27th August 2020

Application No: AB/76/20/L
Site Address: 55-57 High Street Arundel BN18 9AJ
Description of works: Listed building consent for the conversion of existing mixed use space to 1 No one bedroom flat.

Proposed Ground Floor Plan

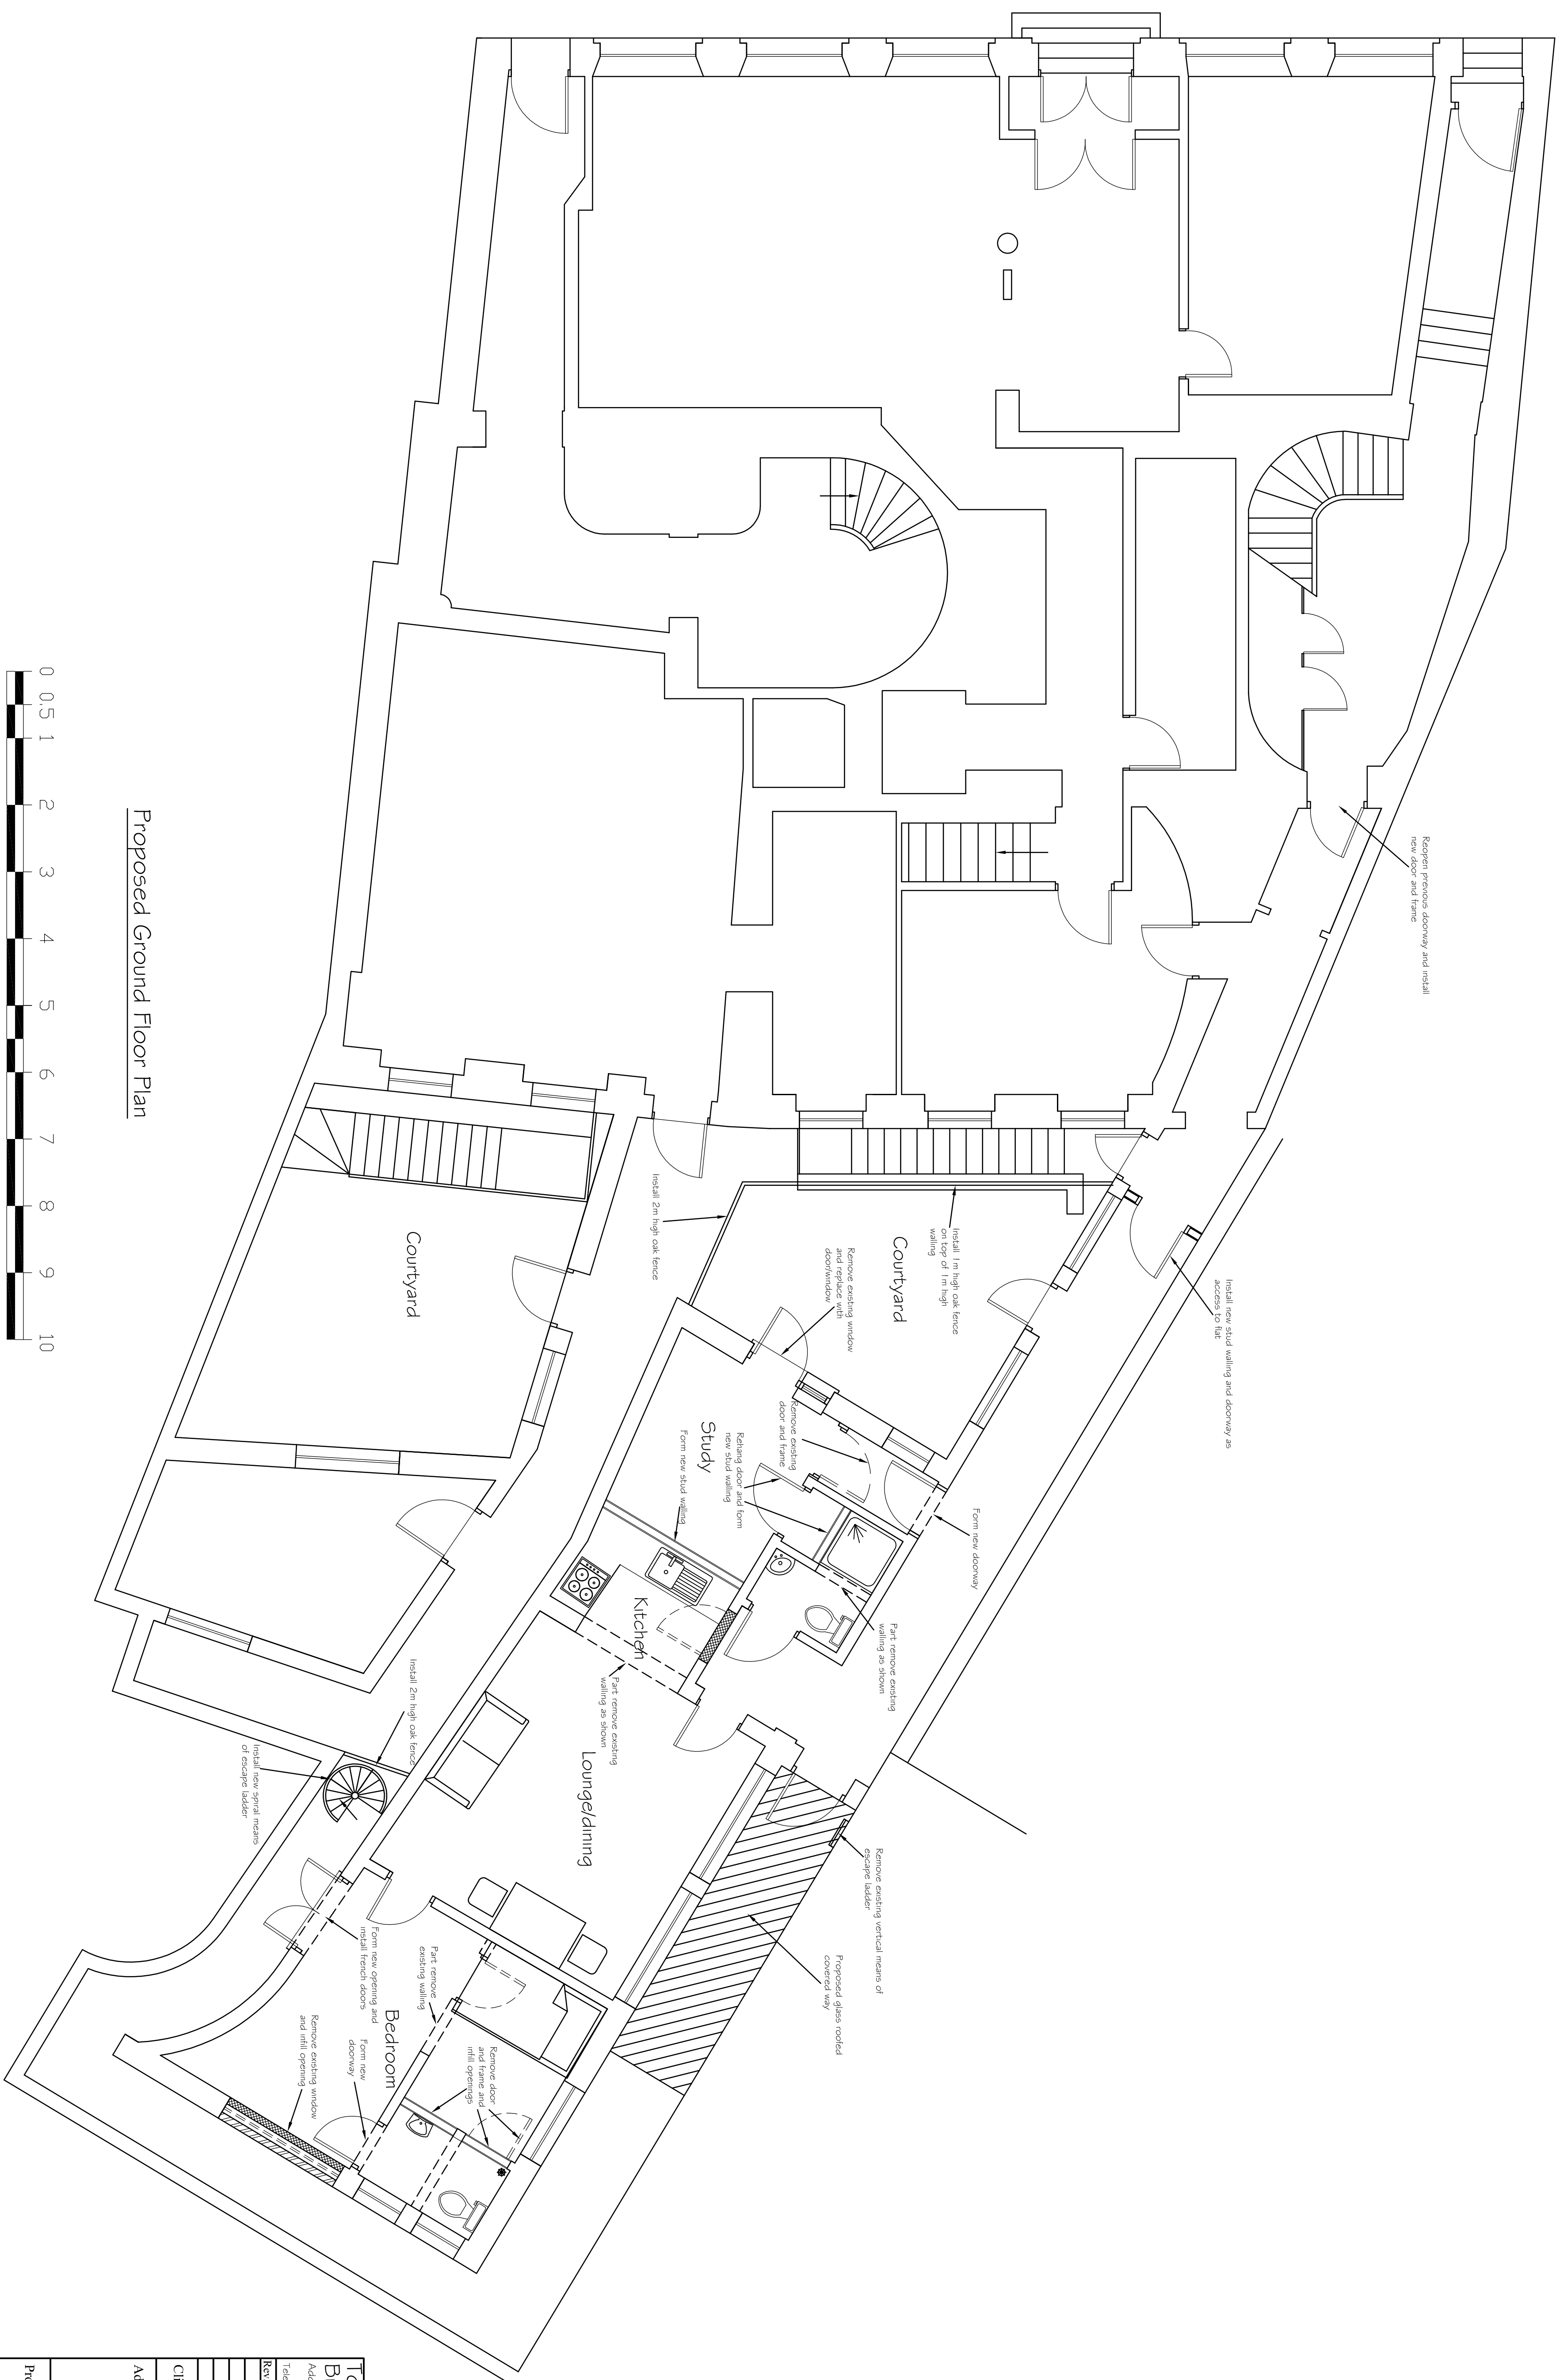
Our property The old printing works shopping arcade BN18 9JH has a fire escape route that has been blocked since the development of the house to the back of our arcade the proposed flat entrance is our fire escape route thus a worry on our part re the safety of our tenants this new entrance no doubt would be part of a plan to use the same to access the current property at the rear of our shopping arcade his current access is through our car park which is somewhat restricted thus I presume his intention would be to make this access more appealing to a future tenant that has not been declared we would also consider this area would be over developed for the restricted access and the amount of traffic generated
